Heckington Fen Solar Park - construction, operation and decommissioning of a ground mounted solar generating facility with a total capacity exceeding 50MW, together with an energy storage facility, below ground grid connection to, and extension at, the National Grid Bicker Fen Substation - Deadline 1 Submission

Post Hearings submission

Applicant's change request application - response to the amended plans and documents

FIGURE 4.27 Land Use Parameter Plan for Design Options at Bicker Fen Substation Extension

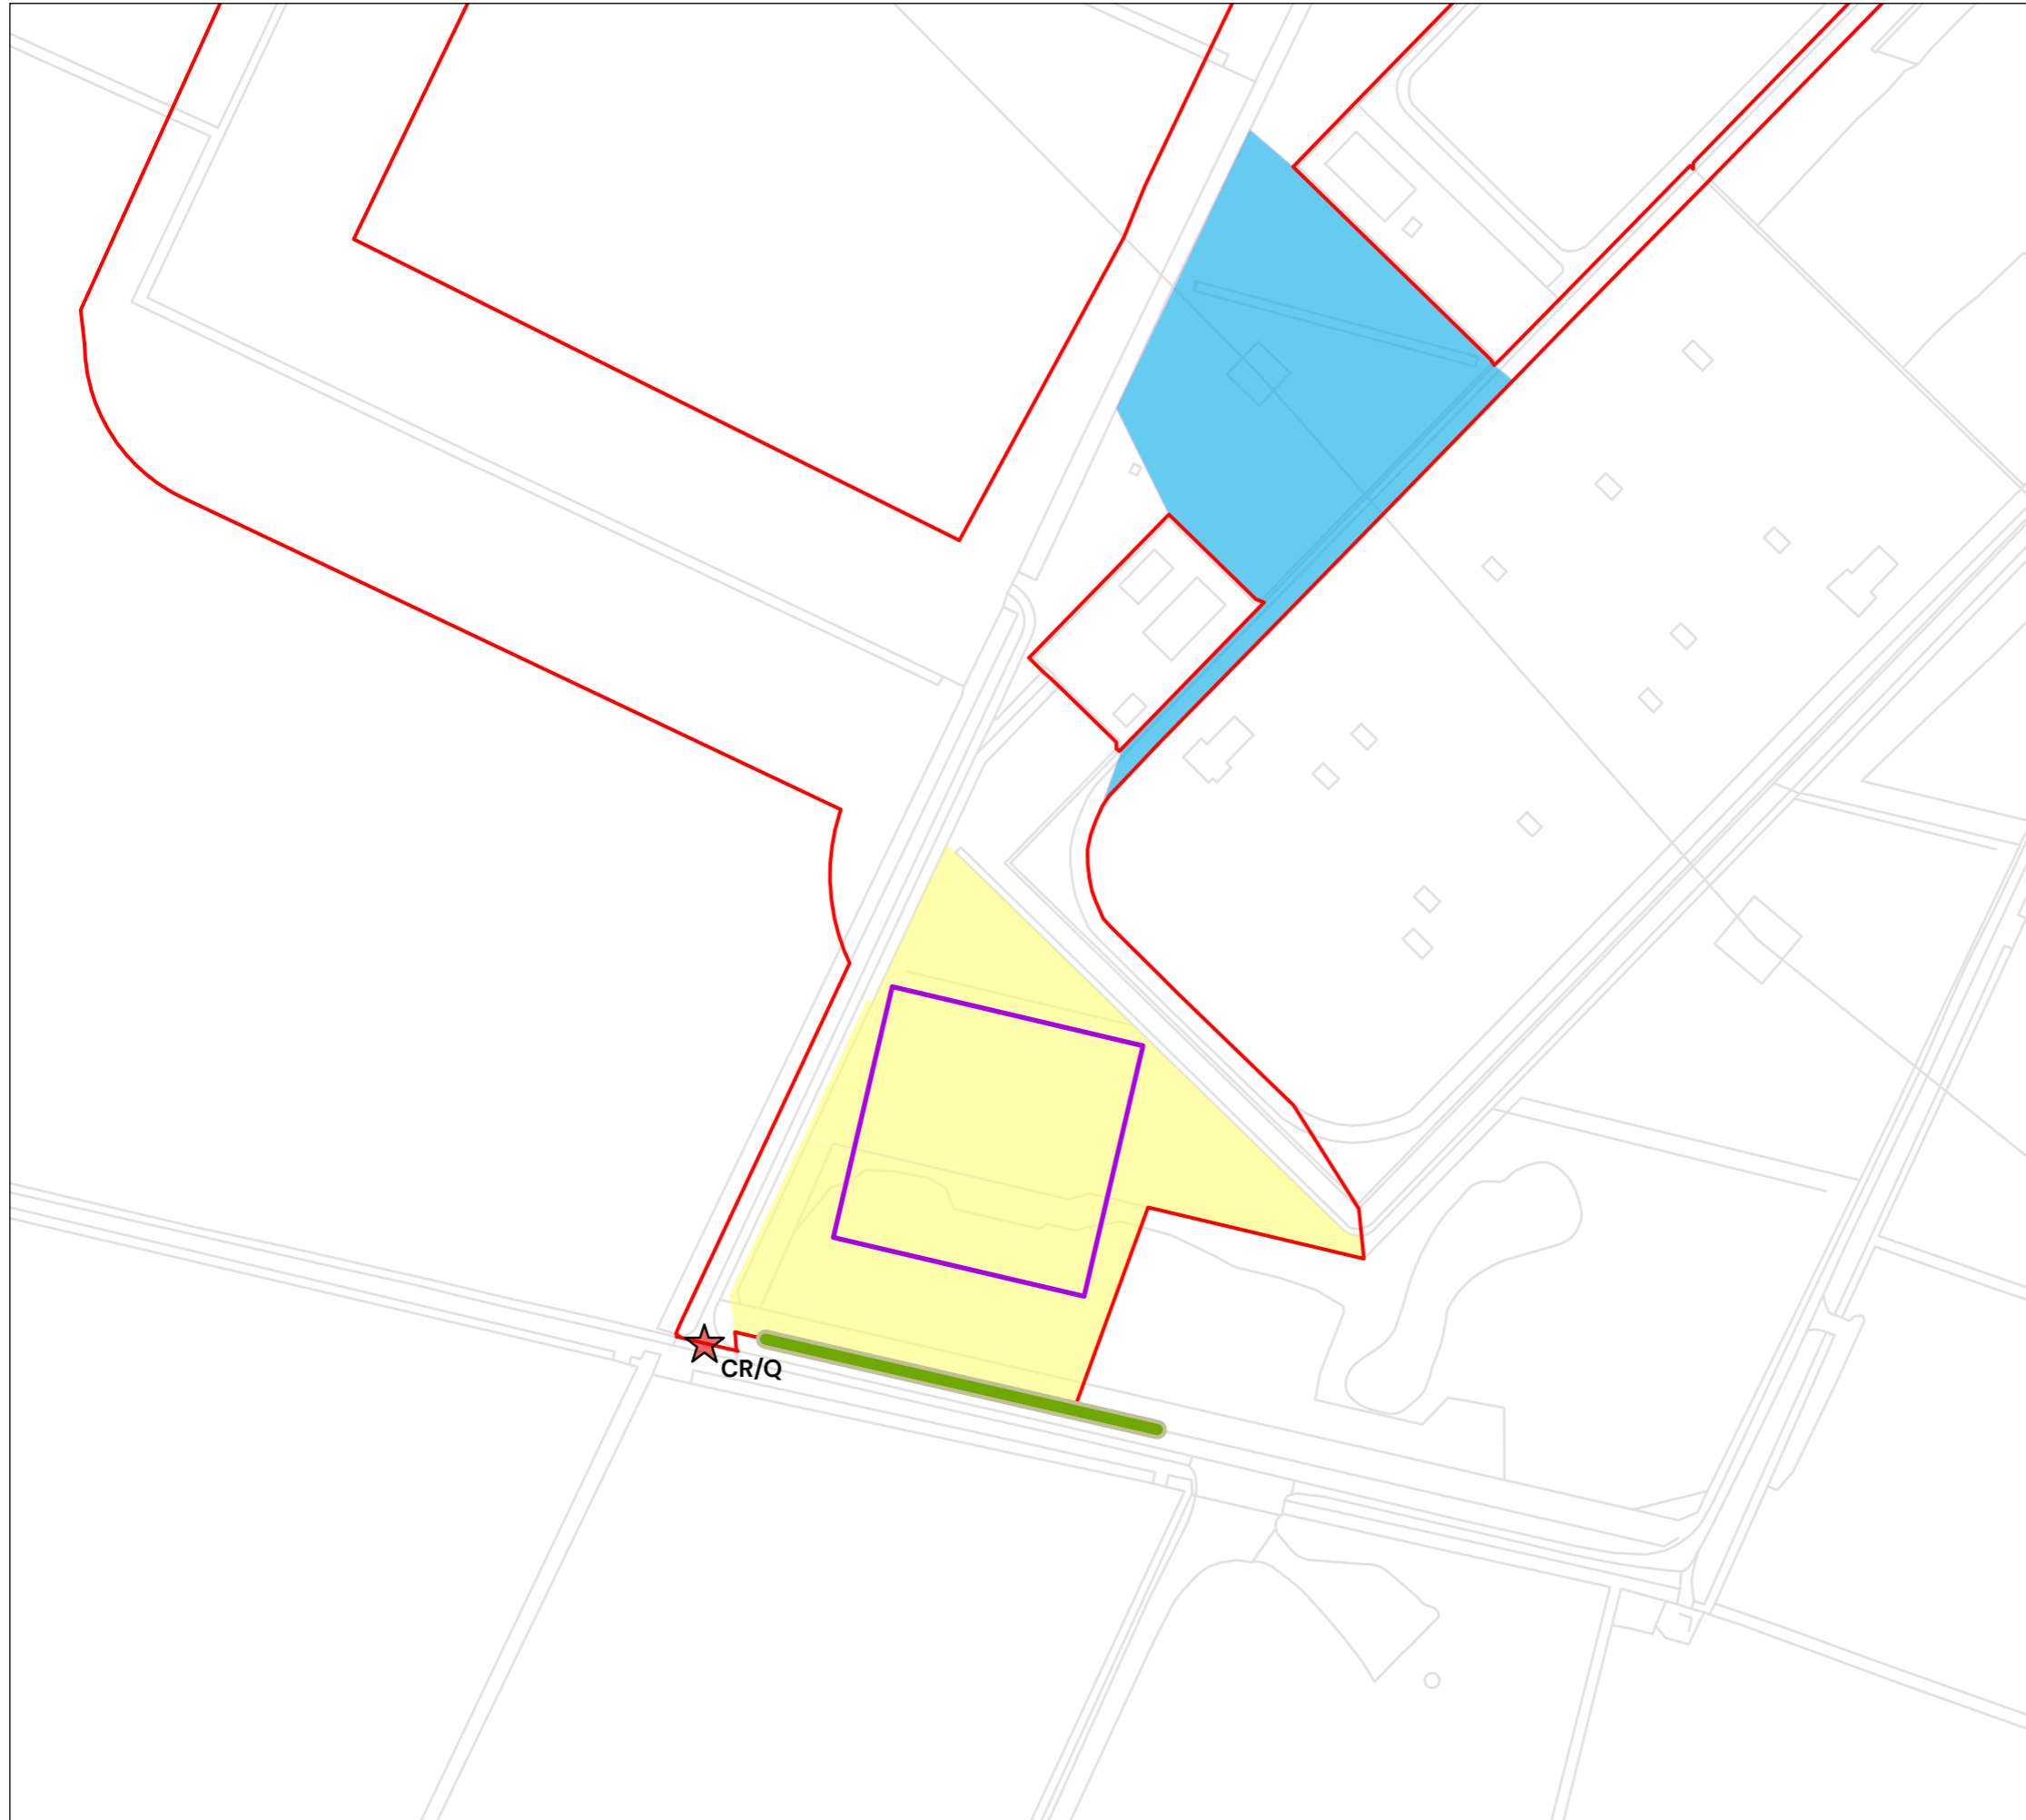
The Environment Agency has reviewed the proposed changes and notes that Bicker Fen is shown to be within the floodplain as detailed on the Environment Agency's Flood Zone Maps. The additional works lie within Flood Zone 3a as described in Table 1 of the National Planning Practice Guidance, (Flood Risk and Coastal Change - paragraph 078).

Environment Agency advice is that all critical infrastructure required to ensure the continuous running of the site is raised above the 1:1000 (0.1% annual probability) plus climate change flood level. This will ensure any equipment required to run the site should remain operational in the event of a flood of that design standard, which is considered to be a more extreme flood event. Providing this mitigation is incorporated into the development we would agree with the Applicant's assessment of '*no significant effects*' in respect of fluvial flood risk for the operational or decommissioning phases related to the Additional Works.
